Re: Juan Tabo Hills Request for CLOMR Response to Comments (Project # 1005278)

Below, please see our response to your comments dated April 8, 2015 for our request for CLOMR for Juan Tabo Hills Estates.

Copyright © 2015 D. MARK GOODWIN & ASSOCIATES, P.A. All Rights Reserved.

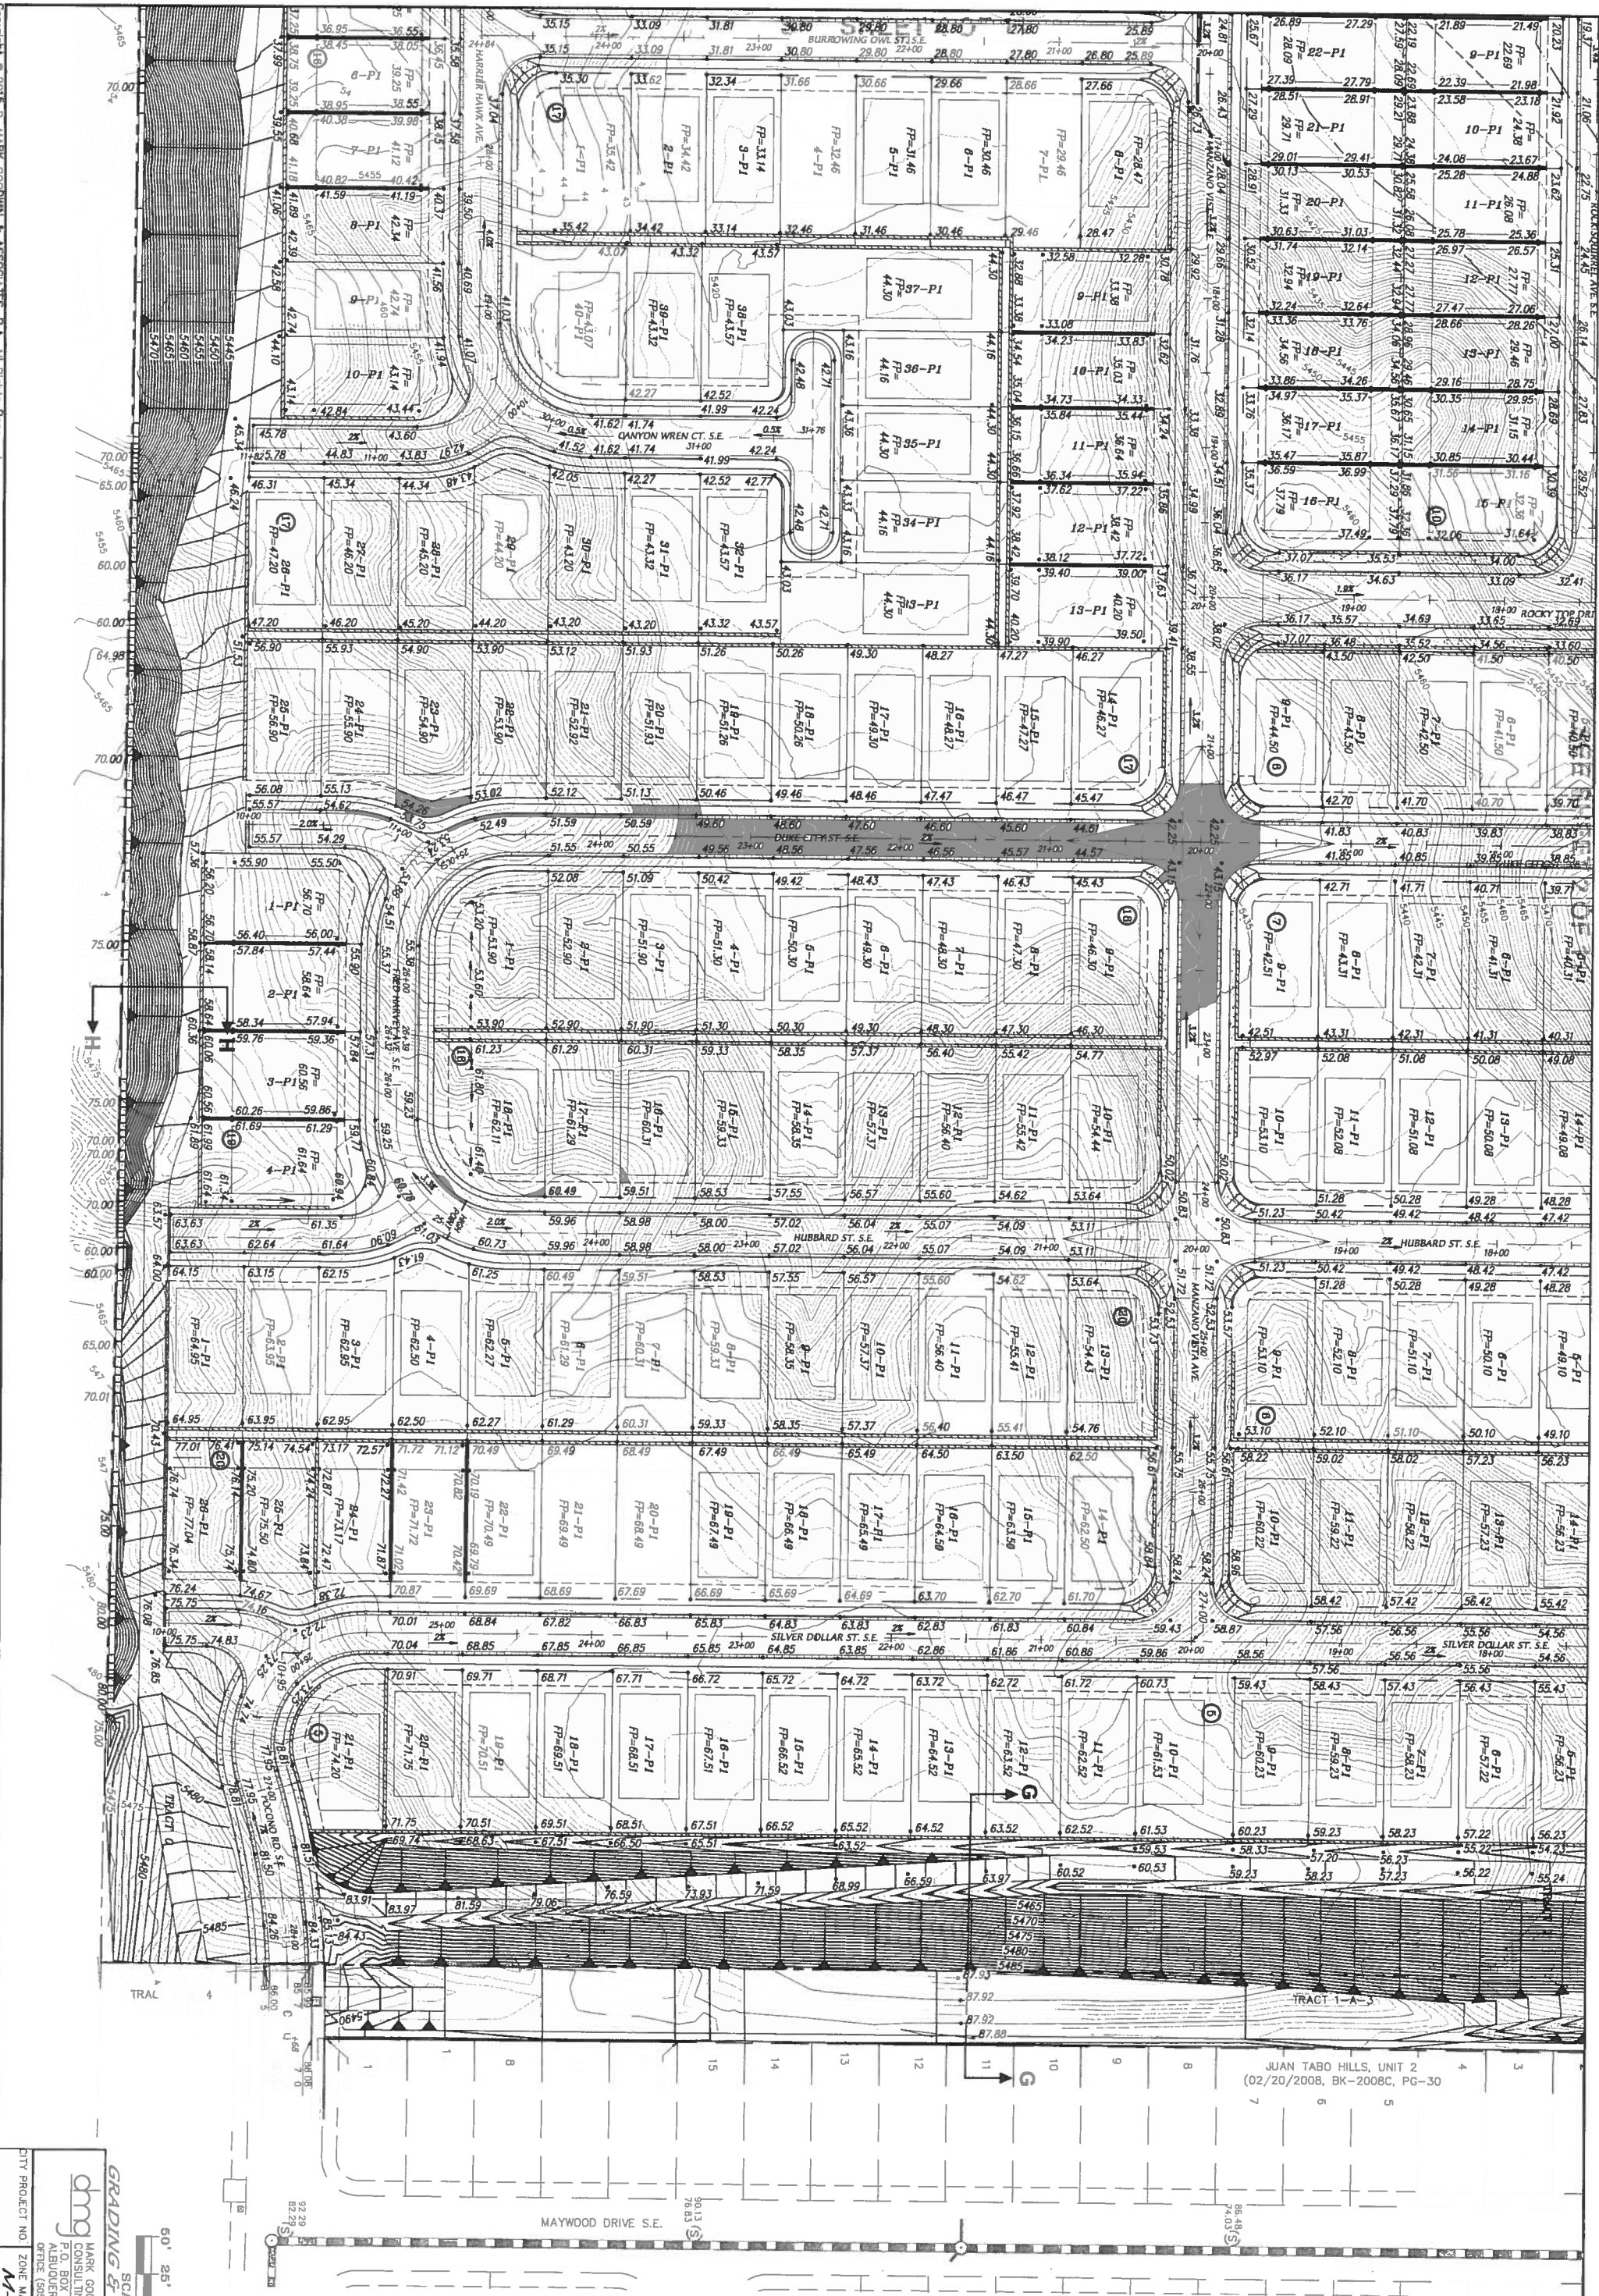
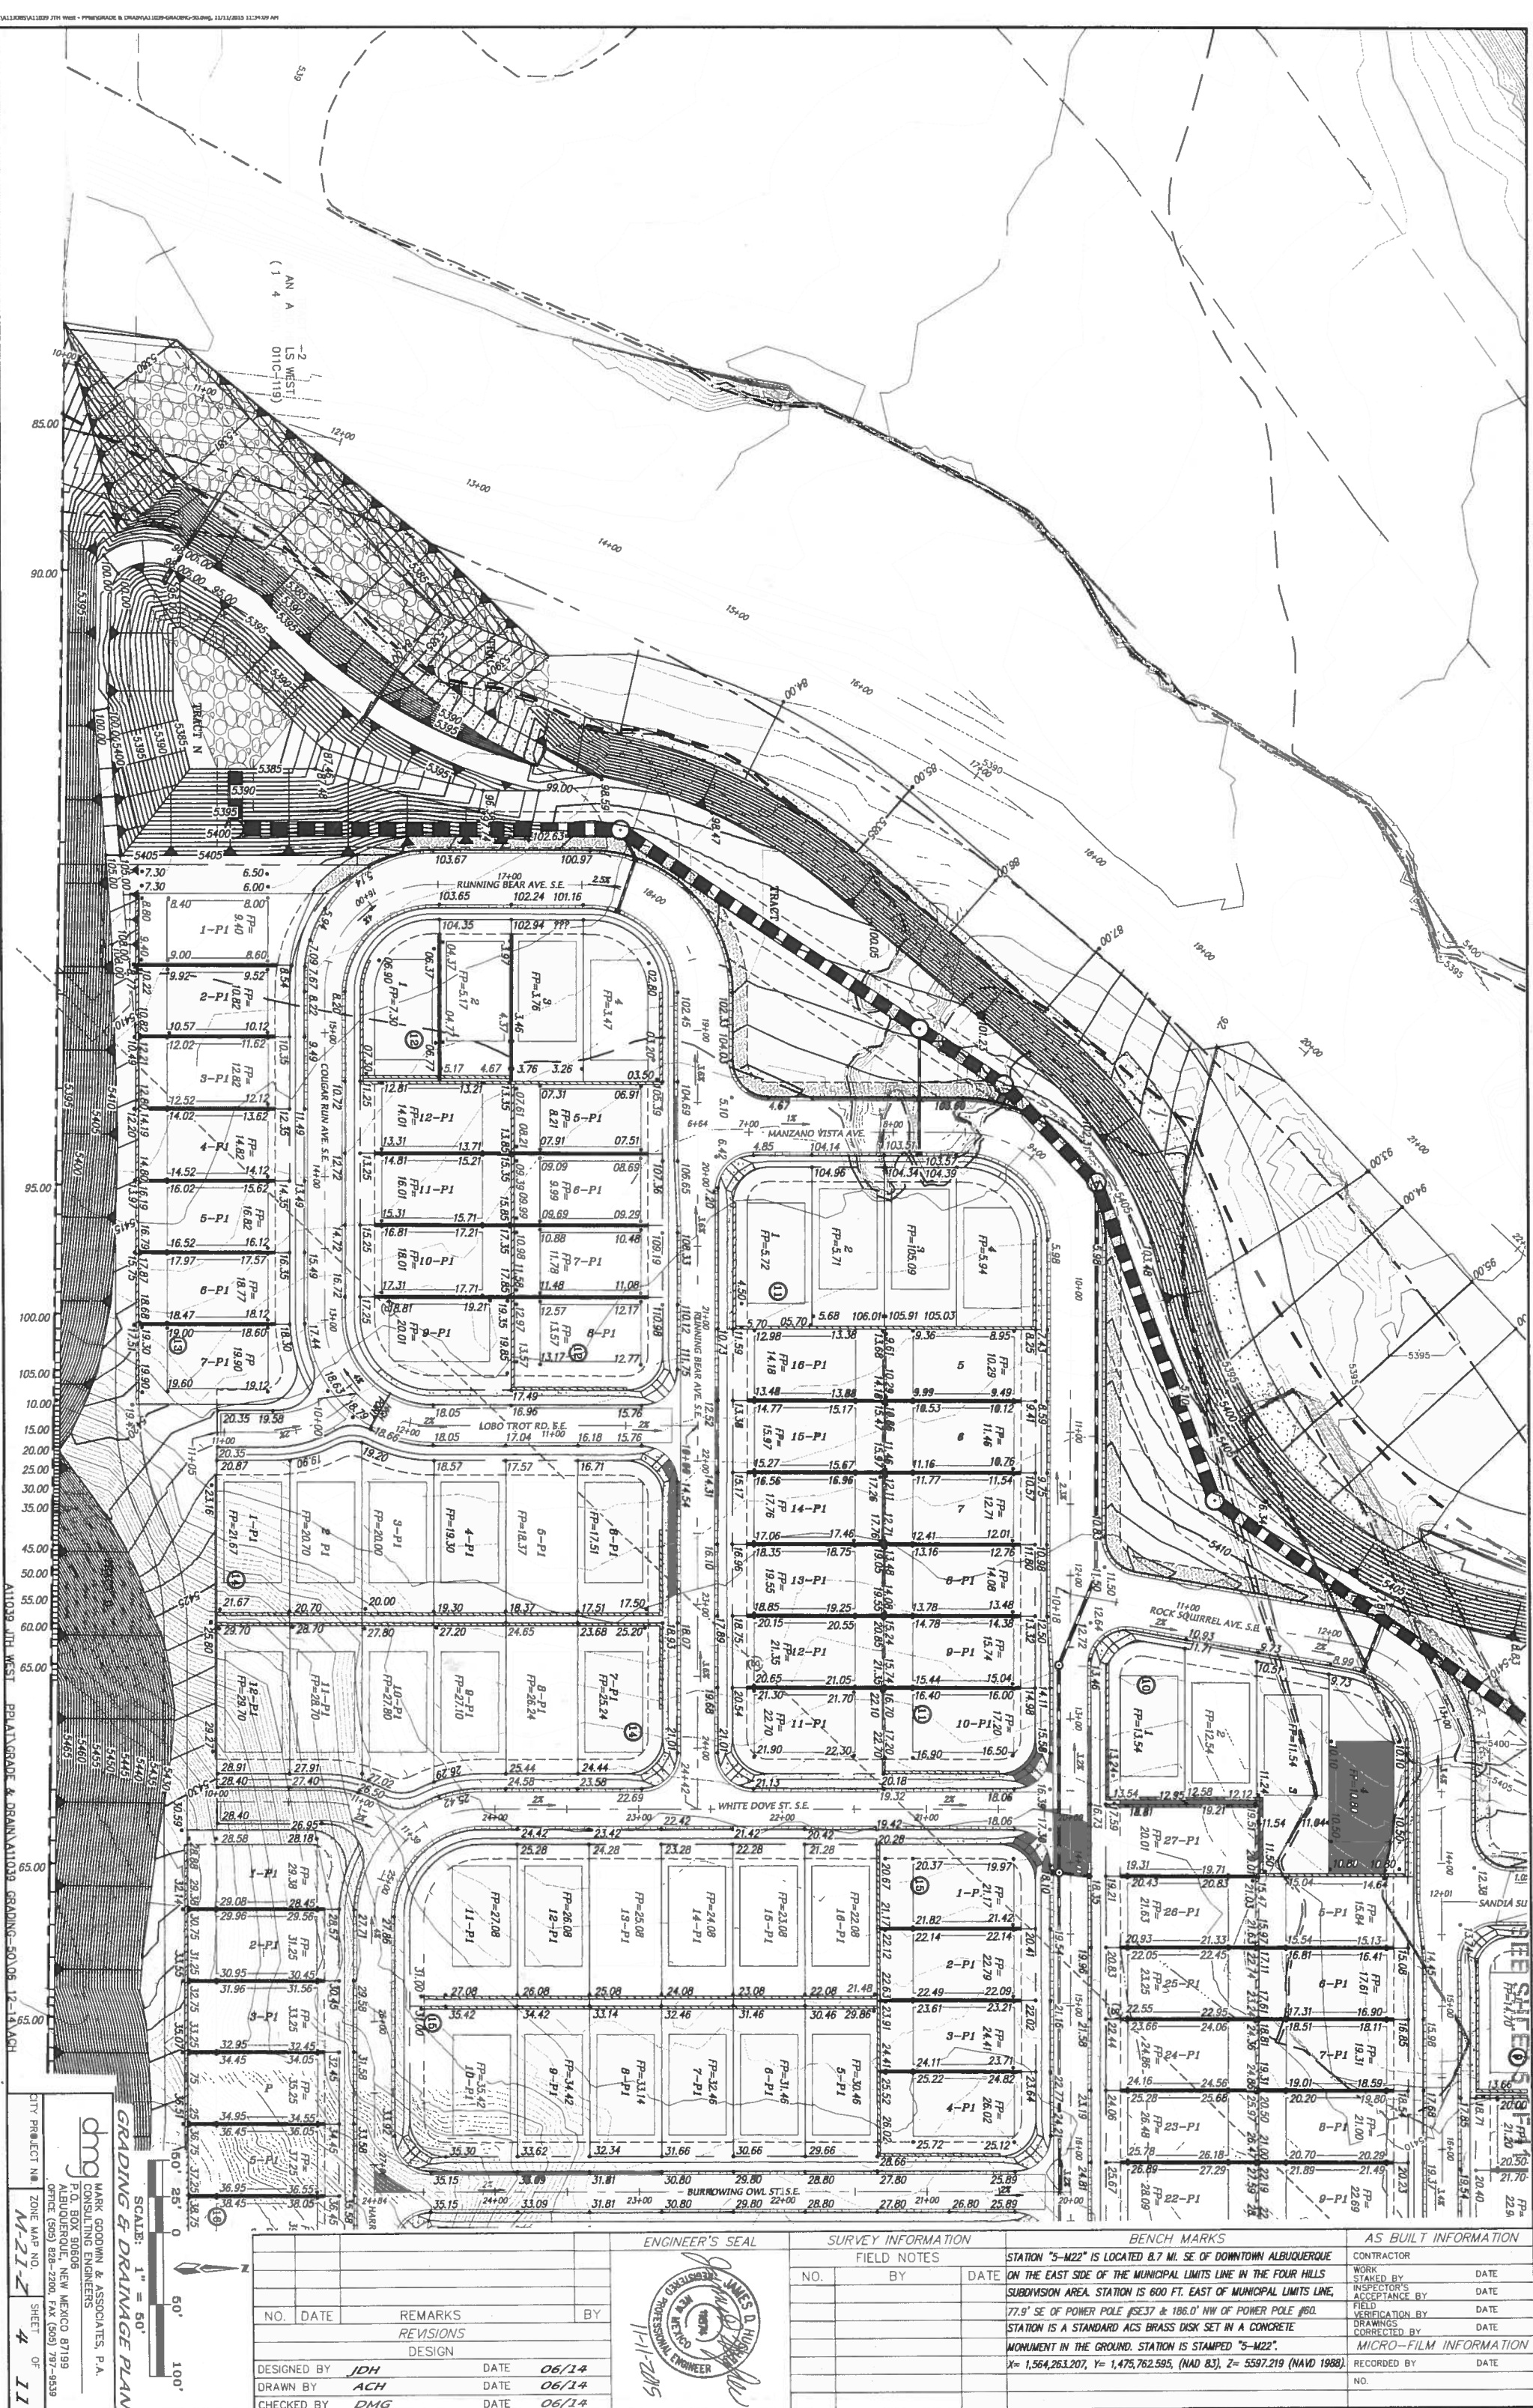
2. A brief review of the grading plan revealed that it was difficult to determine the amount of fill because existing contours were not labeled and spot elevations were not provided. **The revised Grading Plan Contours are now labeled.**

3. The grading plan should show the flood zone(s) and floodway where appropriate. **Flood Zones are now on Grading Plan.**
4. Provide the Annexation agreement. This area is still shown in the County. **Annexation documentation has been added to appendix.**
